RESERVED MATTERS PLANNING APPLICATION, REFERENCE H09-1044-23, ERECTION OF 285 DWELLINGS INCLUDING PARKING, PUBLIC OPEN SPACE, DRAINAGE, INFRASTRUCTURE, LANDSCAPING, ACCESS, APPEARANCE, LAYOUT AND SCALE (PHASE 3) - OUTLINE APPROVAL H09-0521-14 AND RE-SUBMISSION OF H09-0845-22 AND H09-1118-22.

Please find attached amendment form and updated documents in relation to the above Reserved Matters Planning Application, reference H09-1044-23.

PROJECT:	Proposed Residential Development at Holbeach Meadows
DRAWING:	Site Sections Phase 3 - Northern Site Plots (163 No. Plots)
SCALE:	AS SHOWN @ A1
DRAWN:	GB
DATE:	NOVEMBER 2023
REVISION:	A
DRAWING No:	137-SS-15

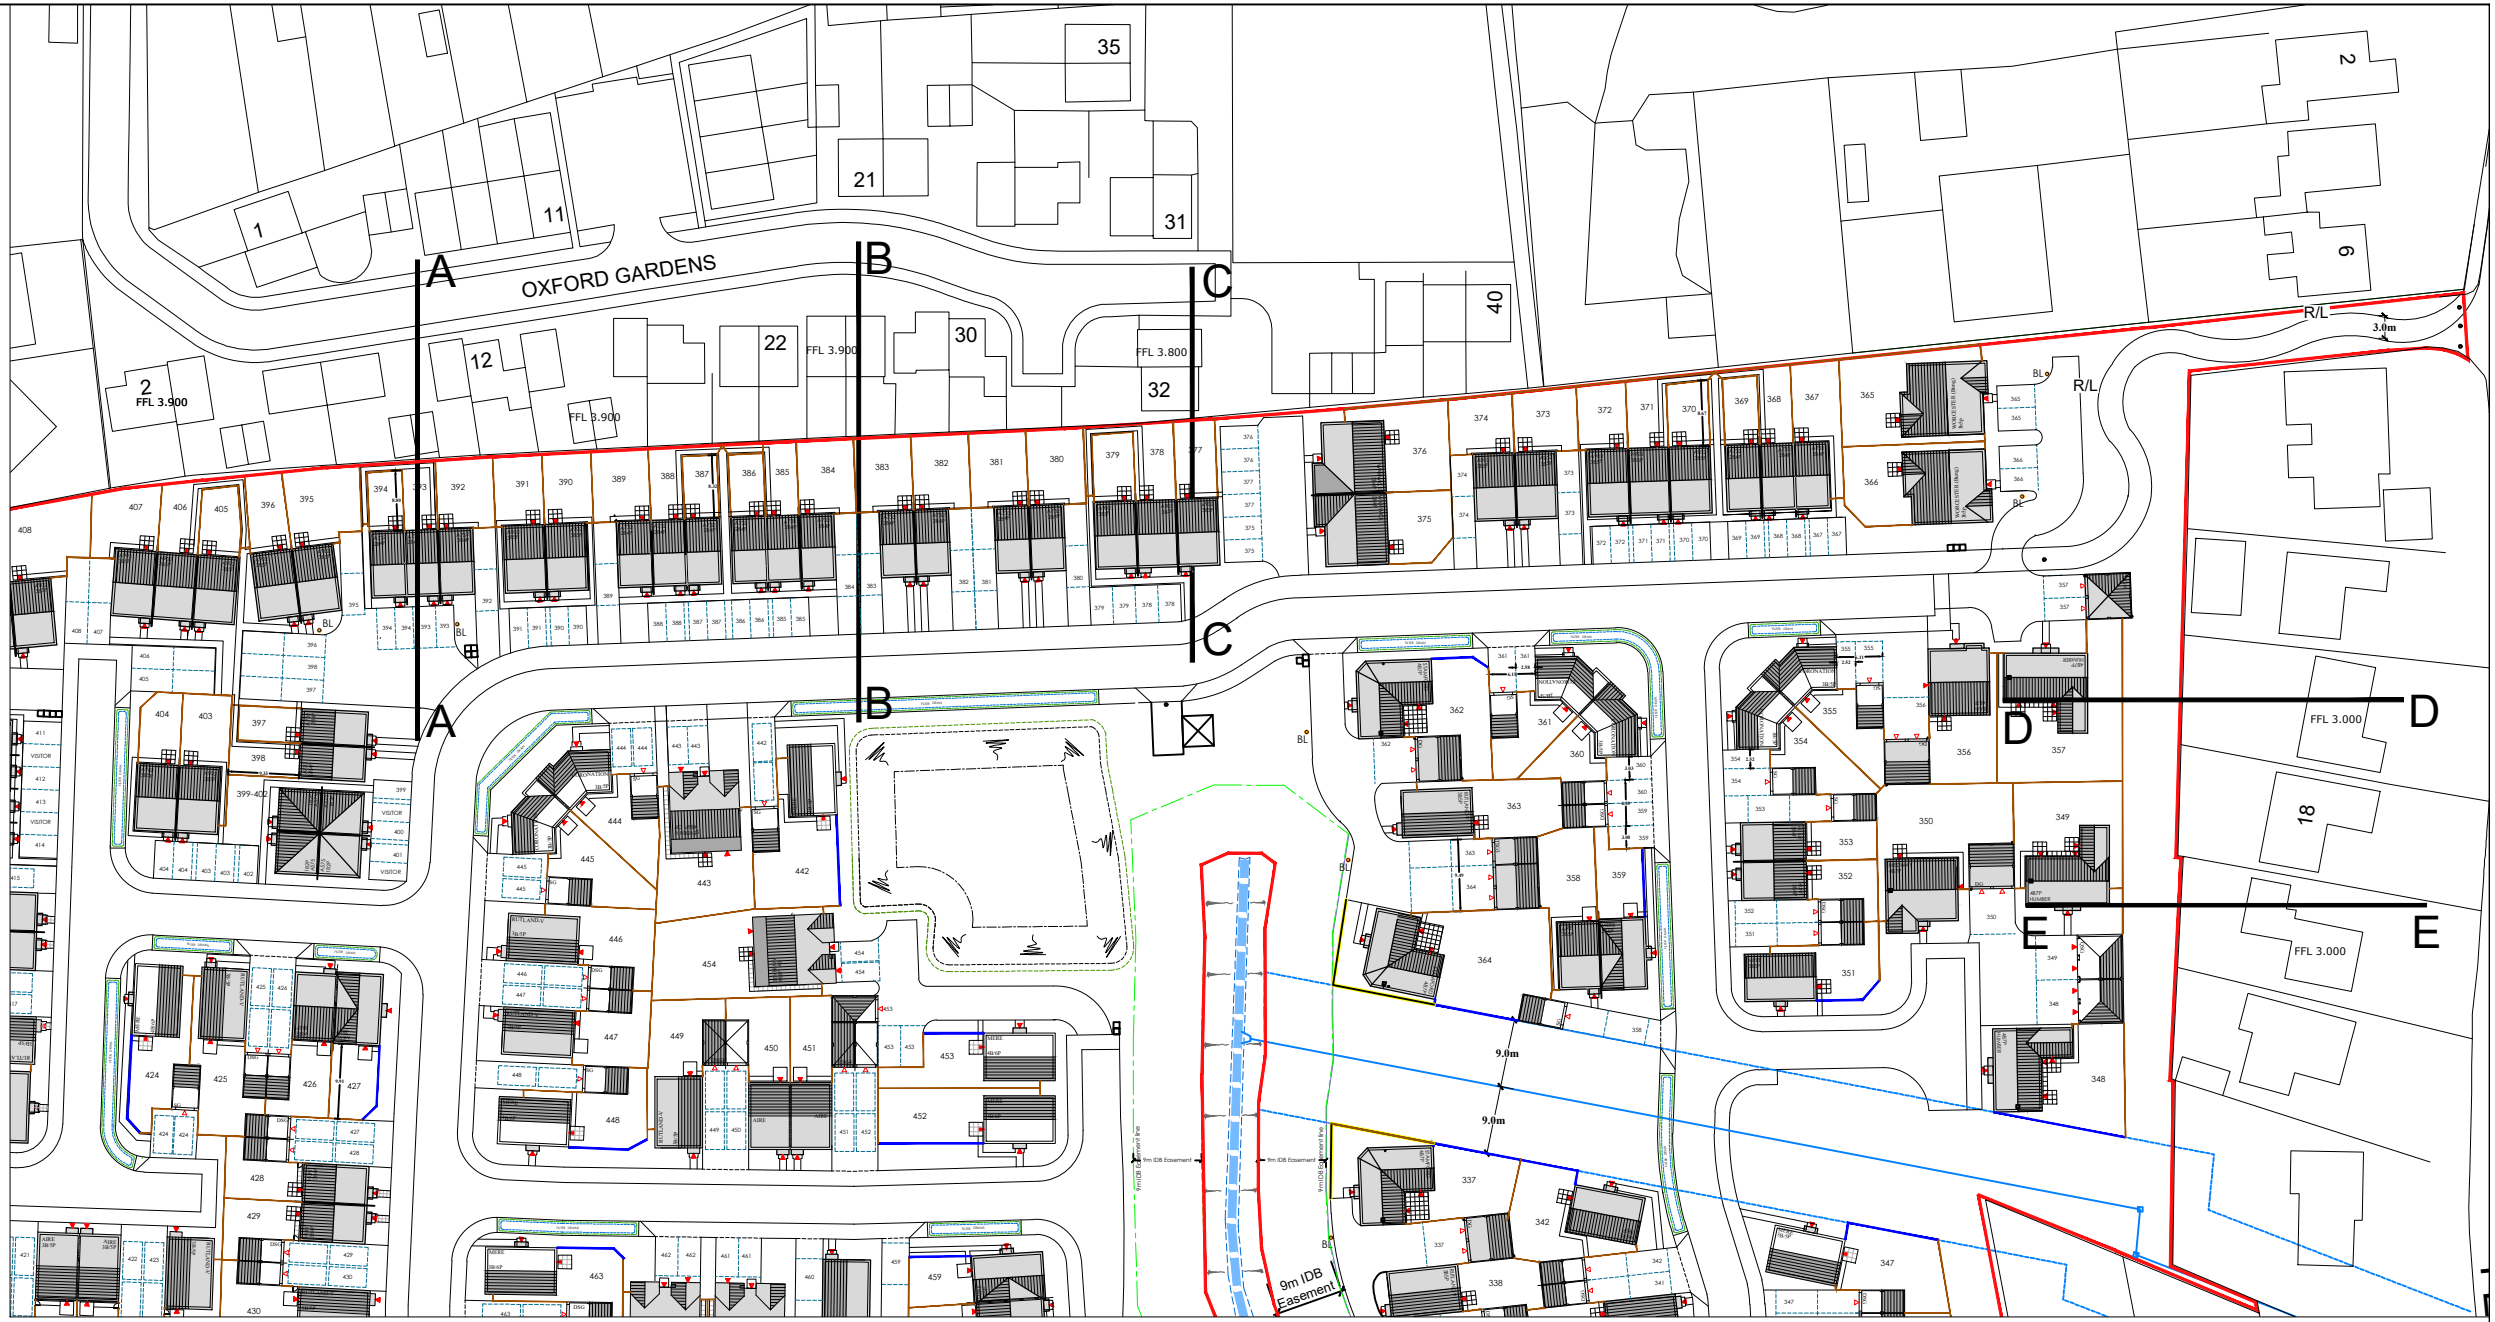
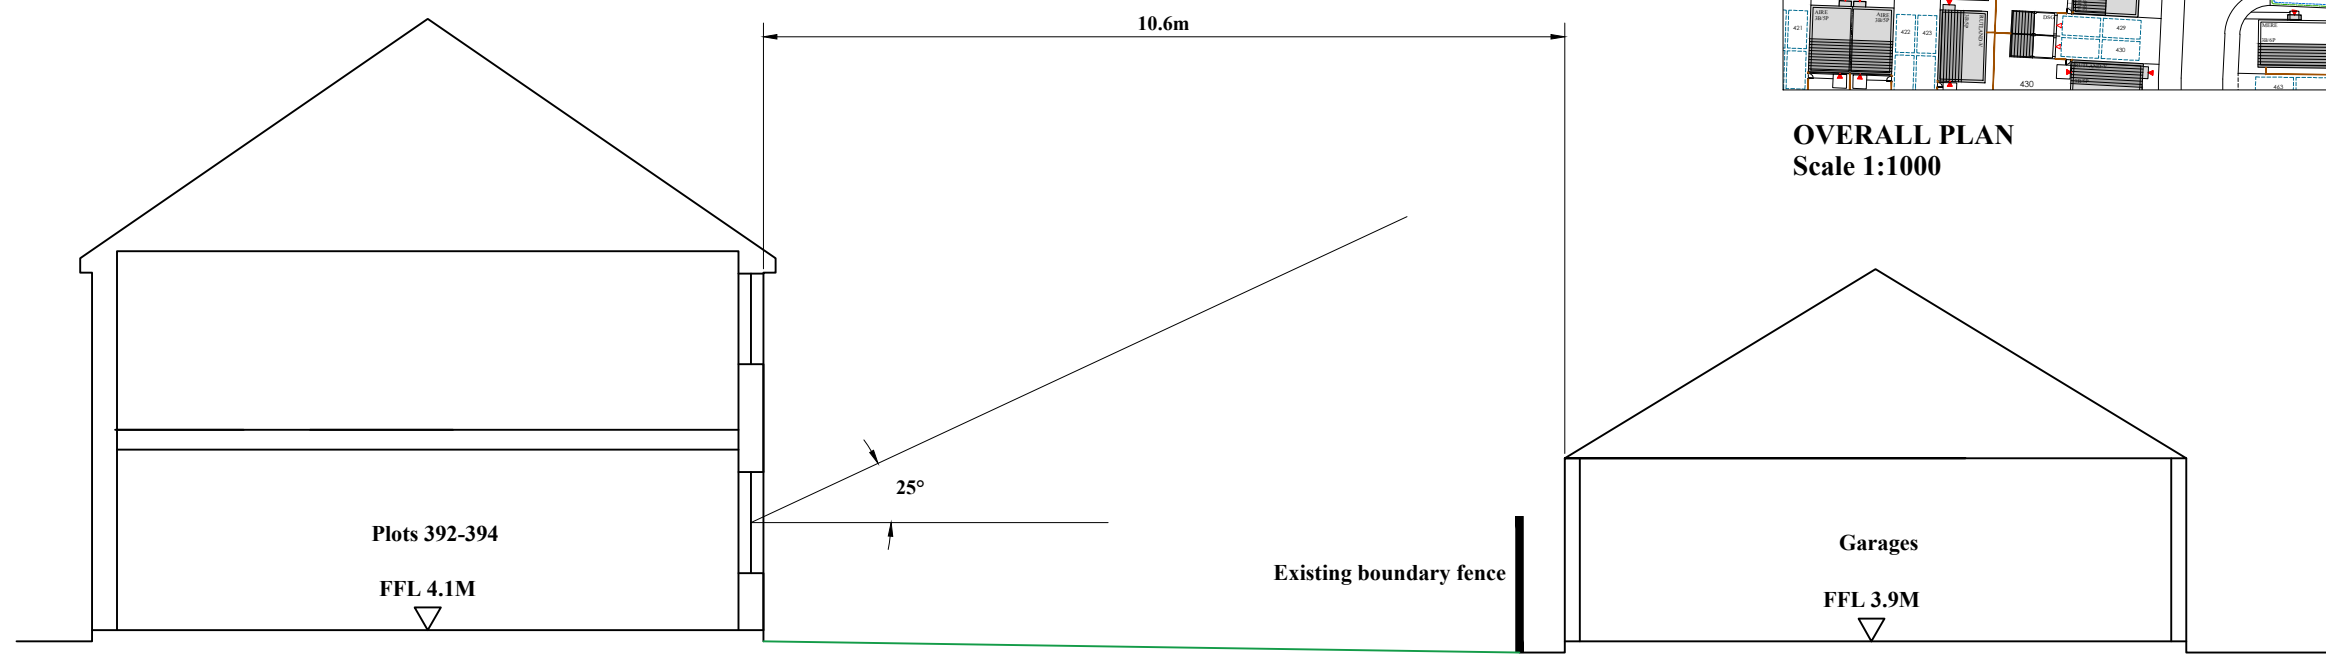
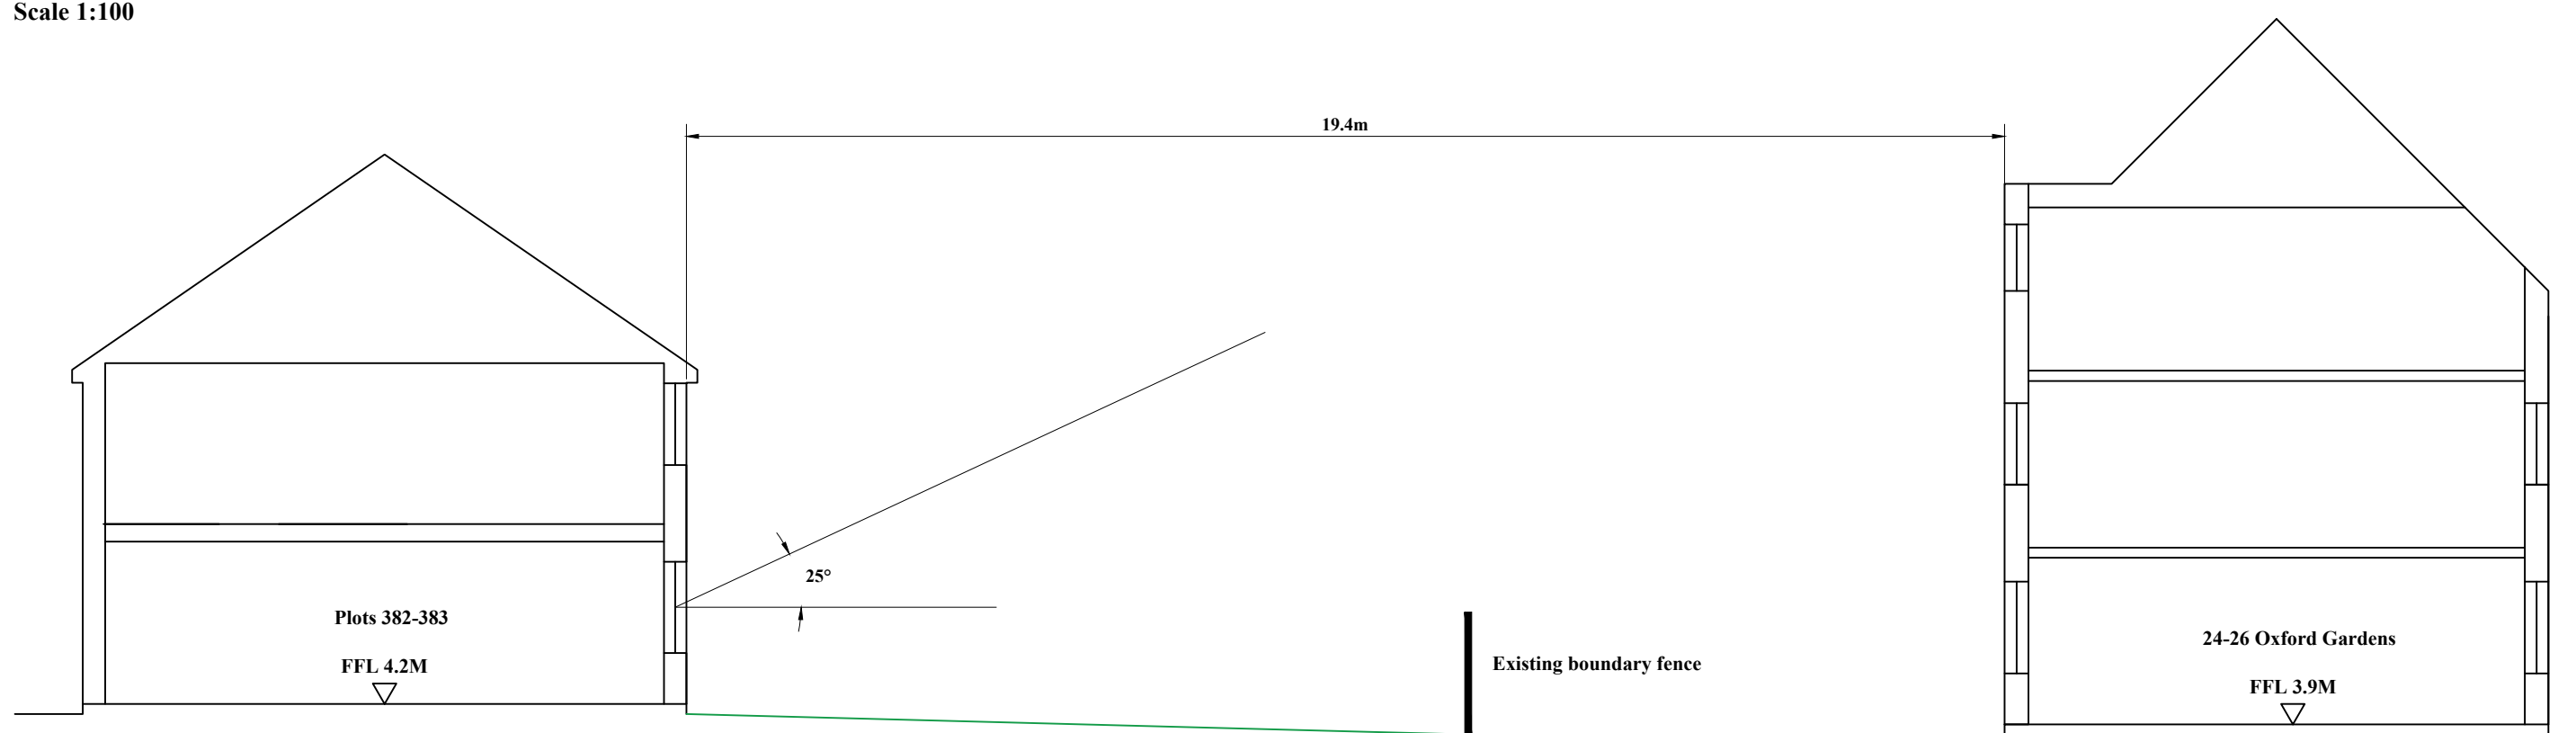
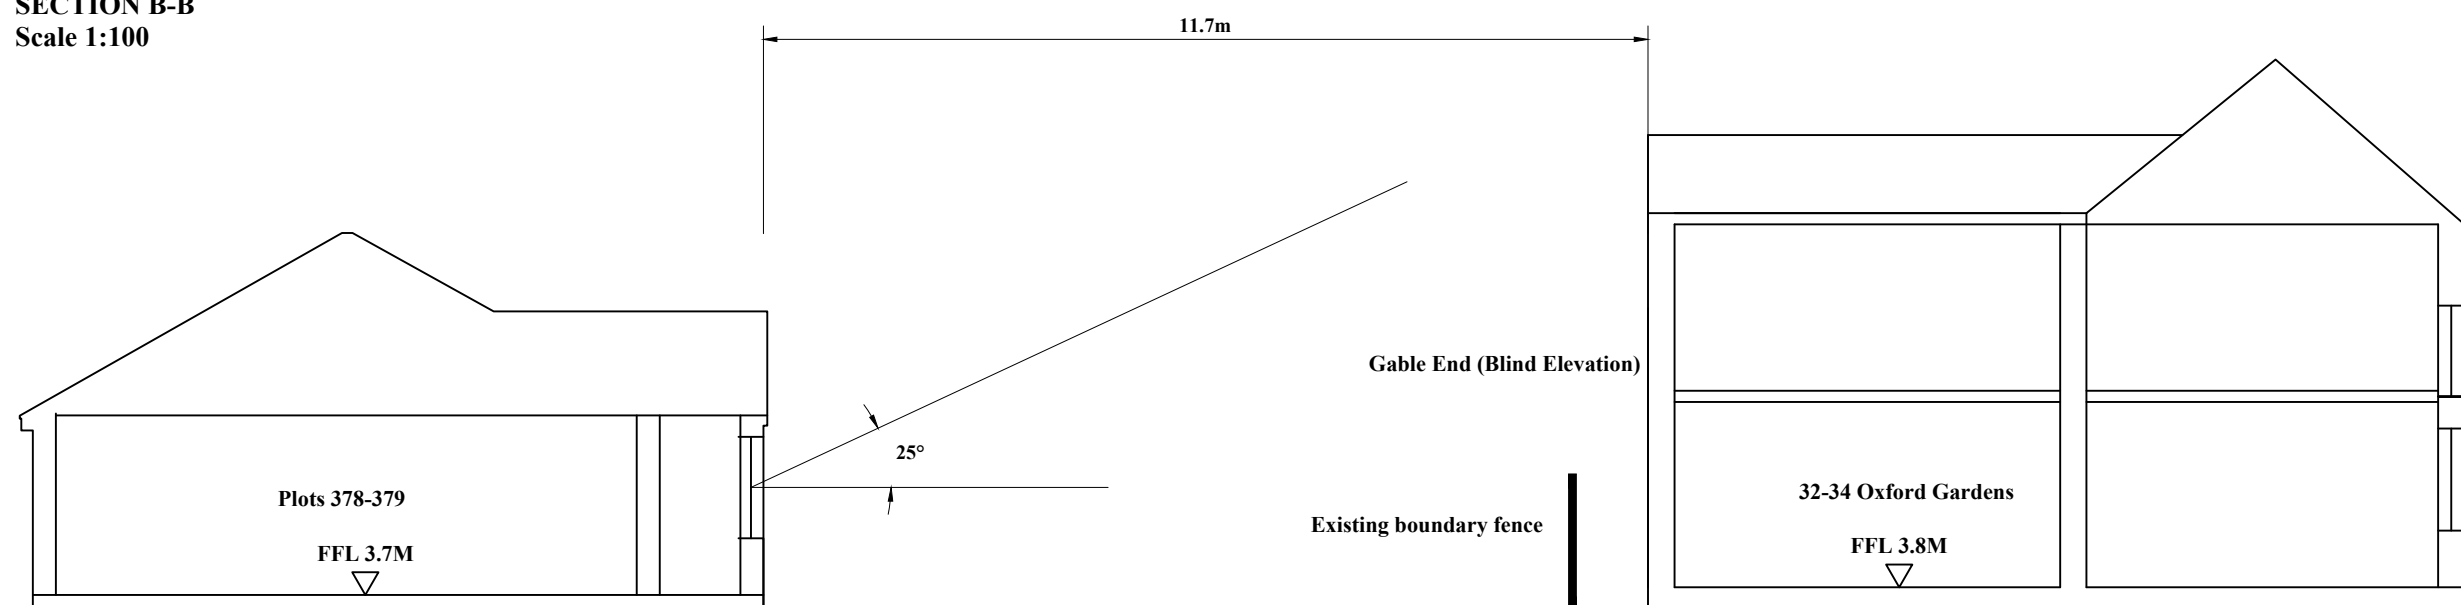
- Garden sizes – we have noted dimensions on the layouts and made some tweaks where necessary to ensure a 8m garden dimension generally. We would prefer to remove these dimensions on the formal submission.
- Housetype schedule – ref attached 137-HS-10 rev B which also states the affordable mix to be provided.
- Shared triple garage 4 – this has been amended to better reflect the other garages.
- Coronation and Stamford – we will add flank windows to the side elevations on these plots which generally face onto their parking. This will be reflected on revised design sheets to be issued when we do the formal submission.
- Plots 349 and 357 rotated and garden fencing moved away from Fen Road plots to create a larger landscape buffer. Sections added to this boundary on drawing 137-SS-15 Rev A Site Sections.
